Application for removal or variation of a condition following grant of
planning permission. Town and Country Planning Act 1990.
Planning (Listed Buildings and Conservation Areas) Act 1990

Development of land to east of The University of Chichester, Bognor Regis Campus to construct an Engineering & Digital Technology Park, new access from Felpham Way, erection of first phase of student accommodation (171 spaces), car parking & associated landscaping. This application affects the setting of listed buildings & affects the character & appearance of the Upper Bognor Road & Mead Lane Conservation Area. This is a Departure from the Development Plan.

STUDENT ACCOMMODATION - PHASE 1
Minor Material Amendment:

DRAWING TITLE
Proposed Ground Floor Plan

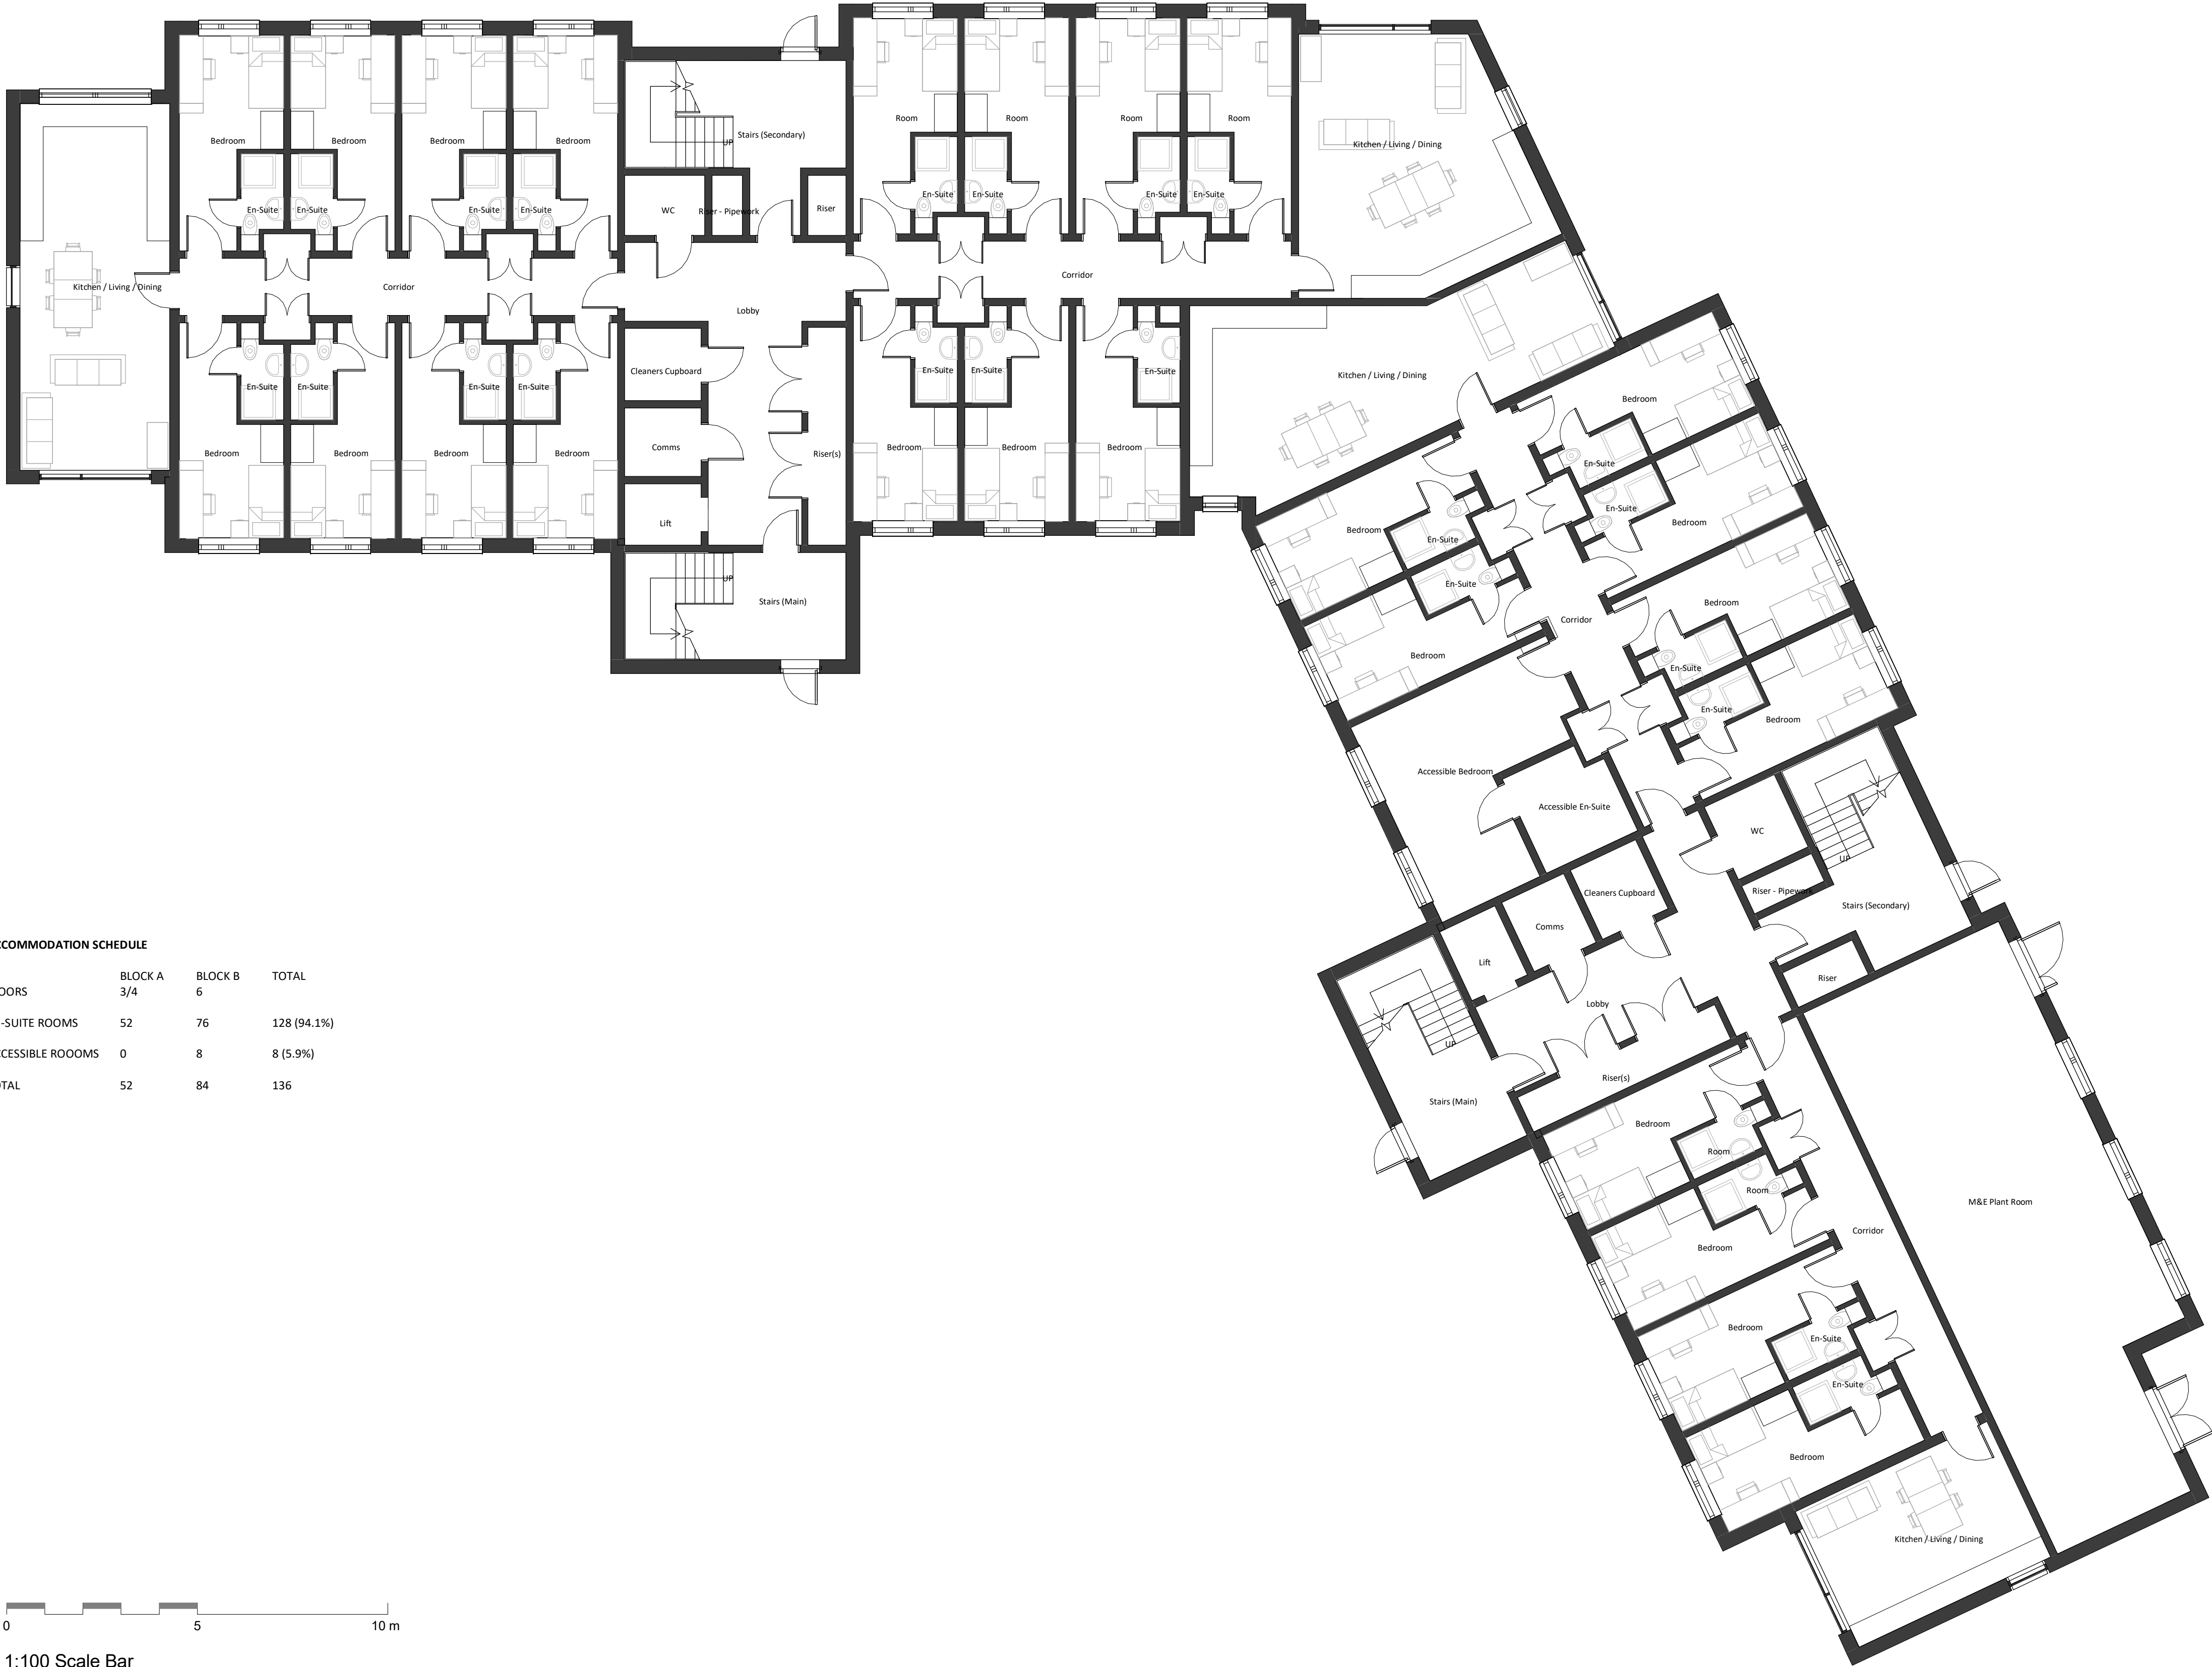
Amendment to the approved scheme to incorporate an additional stairwell to allow alternative means of escape from each cluster (to meet the change in risk profile following the fire at Grenfell Tower), with consequential adjustments to the plans and elevations.

Minor alterations to provision of en-suite, affordable and disabled accommodation, with the overall number of bed spaces remaining unchanged.

151933_STL_XX_00_DR_A_XXXX_01001 - Proposed Ground Floor Plan
151933_STL_XX_01_DR_A_XXXX_01002 - Proposed First Floor Plan
151933_STL_XX_02_DR_A_XXXX_01003 - Proposed Second Floor Plan
151933_STL_XX_03_DR_A_XXXX_01004 - Proposed Third Floor Plan
151933_STL_XX_04_DR_A_XXXX_01005 - Proposed Fourth Floor Plan
151933_STL_XX_05_DR_A_XXXX_01006 - Proposed Fifth Floor Plan
151933_STL_XX_XX_DR_A_XXXX_02001 - Proposed East and South Elevations
151933_STL_XX_XX_DR_A_XXXX_02002 - Proposed NW and NE Elevations
151933_STL_XX_XX_DR_A_XXXX_02003 - Proposed West and SW Elevations
